June 7, 2019

**Re: Horizon 3**  
**8830 horizon Blvd NE Albuquerque NM**  
**Traffic Circulation Layout**  
Engineer's/Architect's Stamp **05-28-2019** (C17D127)

Based upon the information provided in your submittal received 06-05-19, the above referenced plan cannot be approved for Building Permit until the following comments are addressed:

Traffic Circulation Layout  
 SITE DETAILS  
**TCL002**

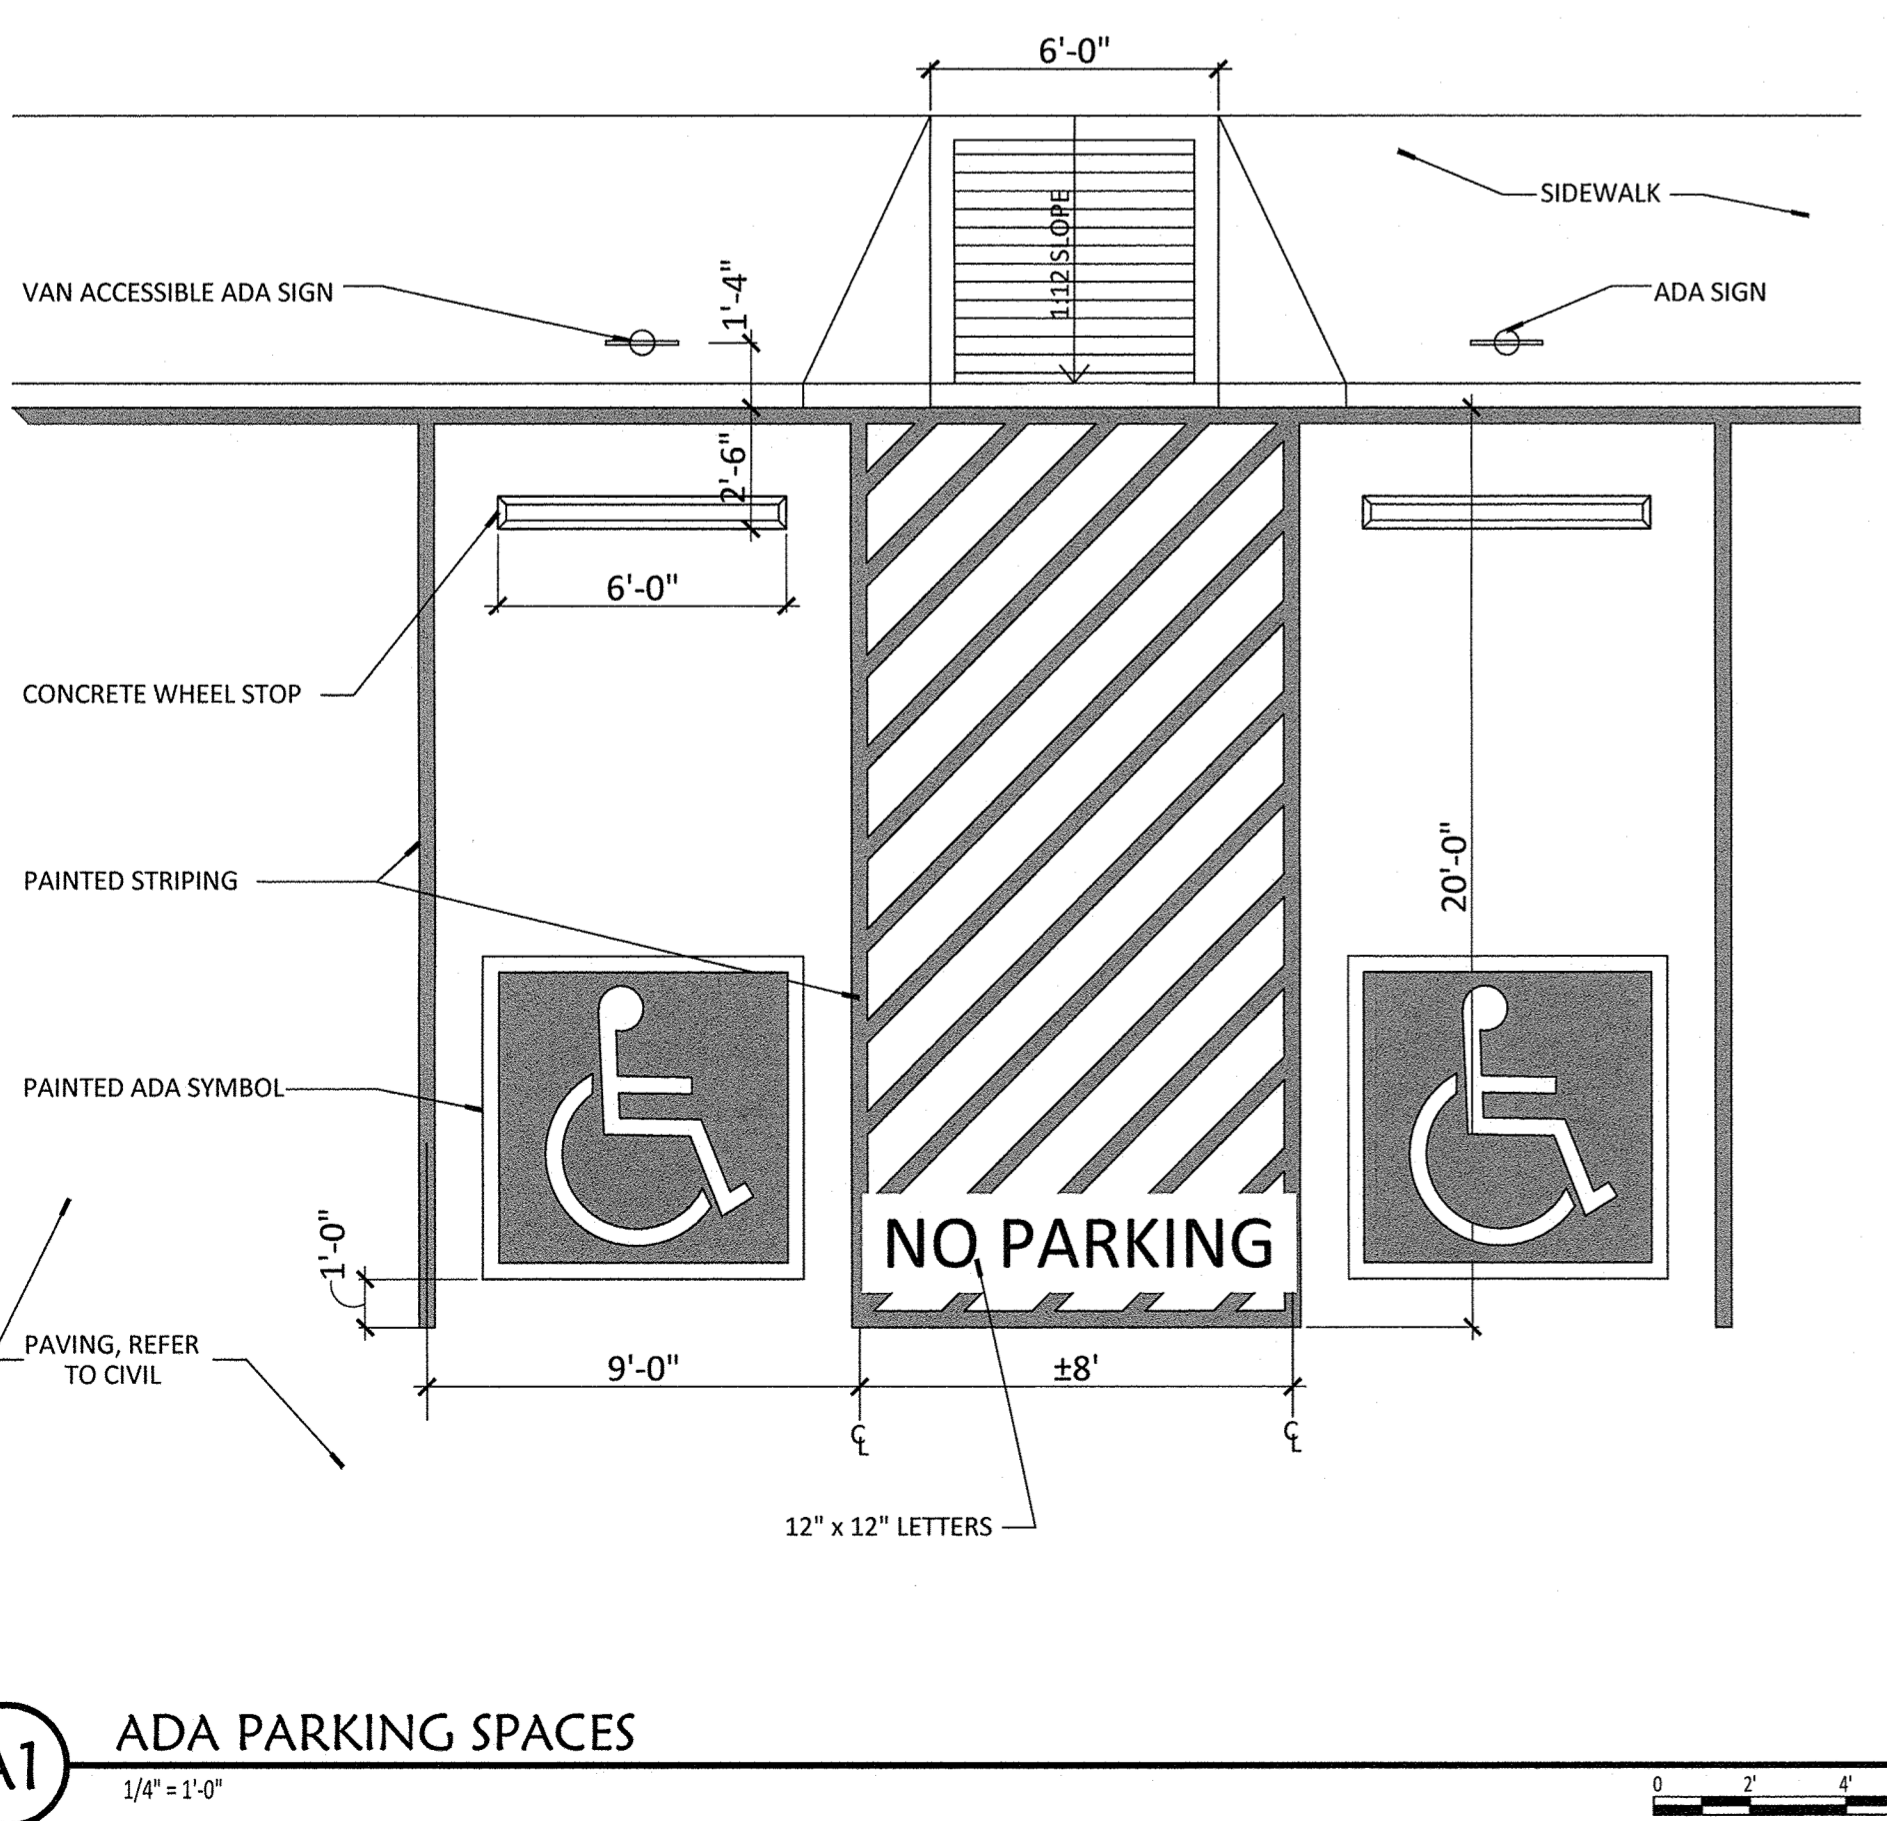
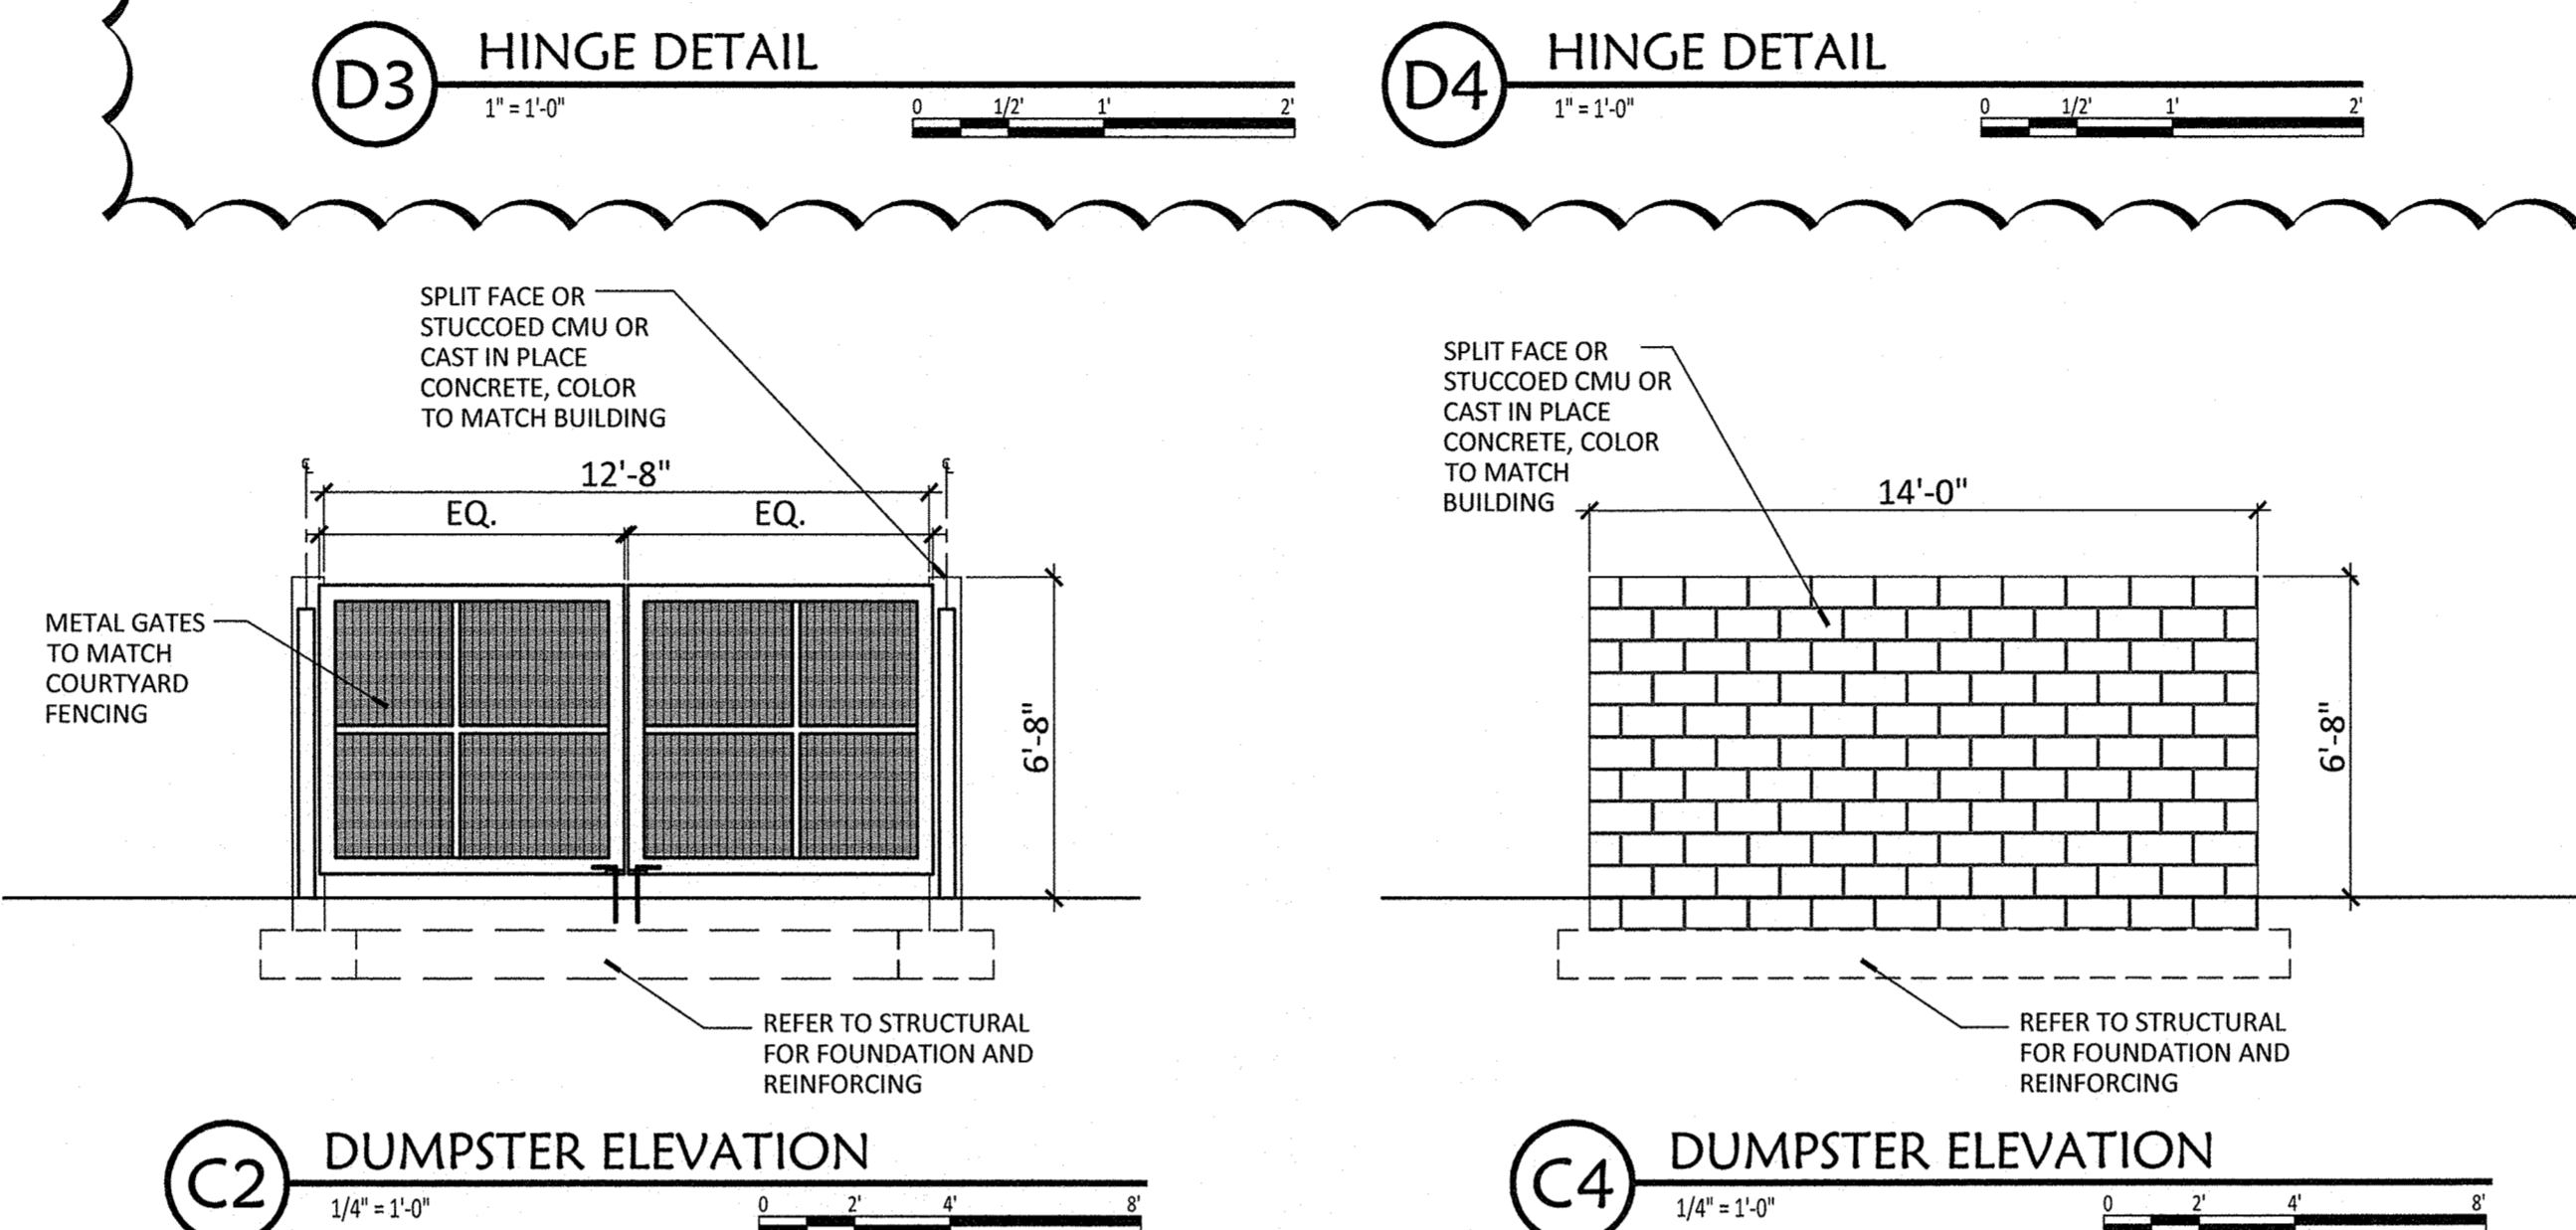
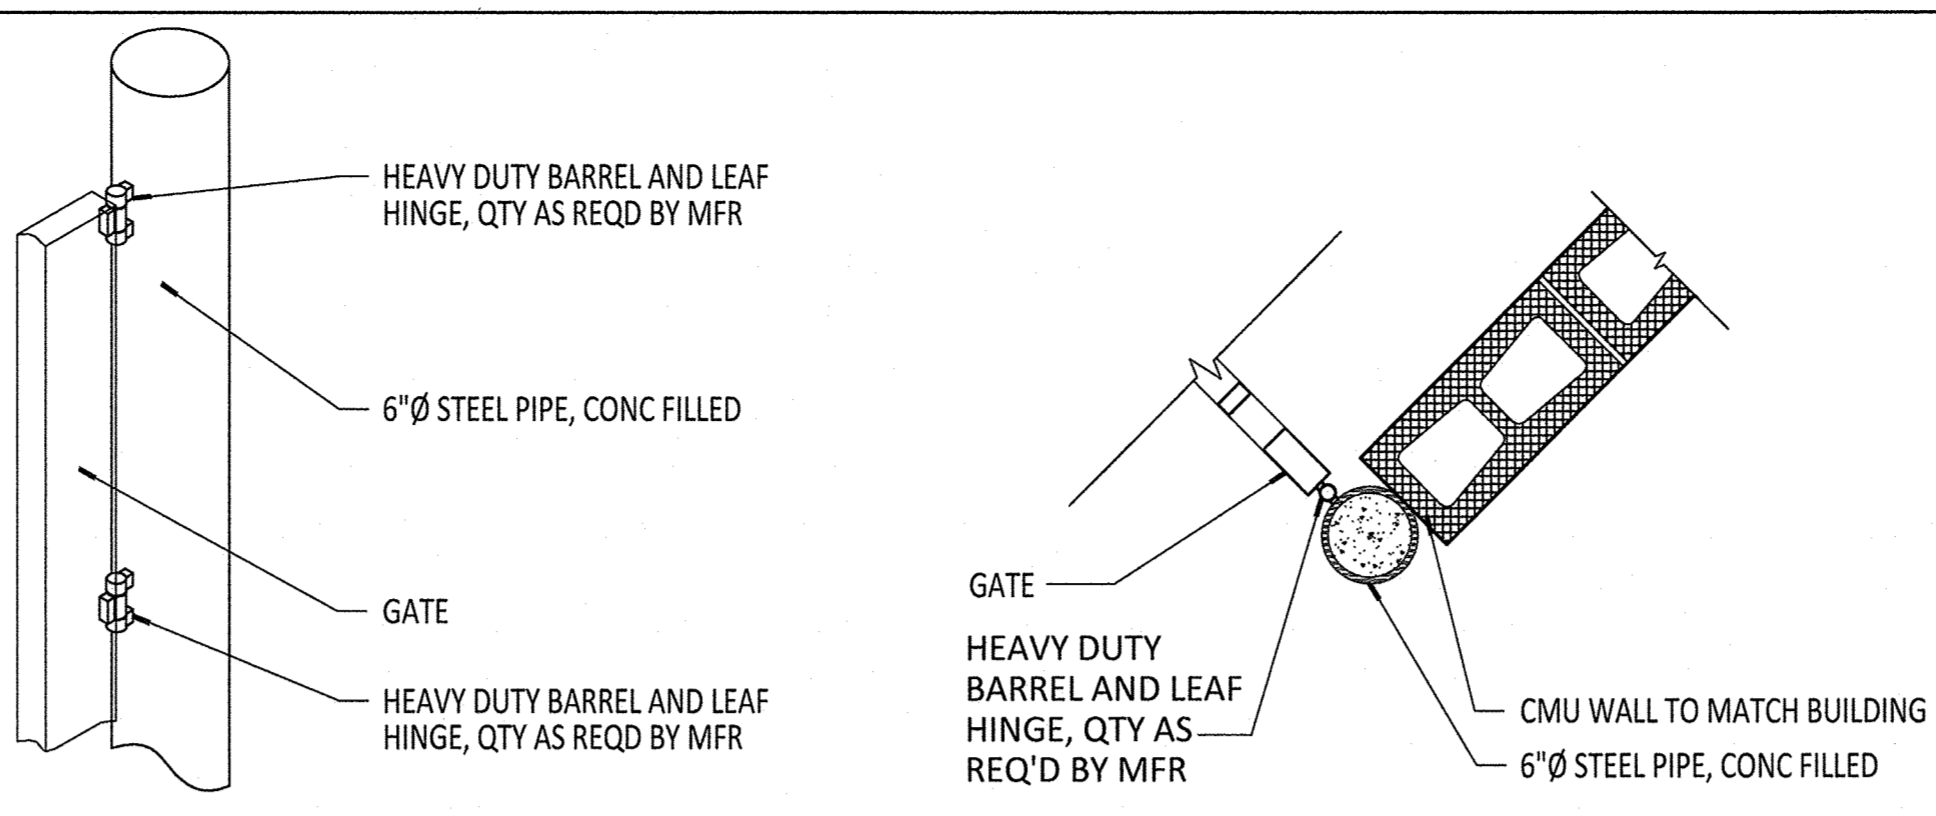
5. Please refer to the attached file for bike rack design as IDO and DPM have new requirements.

5. Bicycle parking should be in the form of a corral or other vertical feature that clearly demarcates the space as intended for bicyclists only. Corrals are most appropriate at street corners. See Figure 3.8-3 for examples.
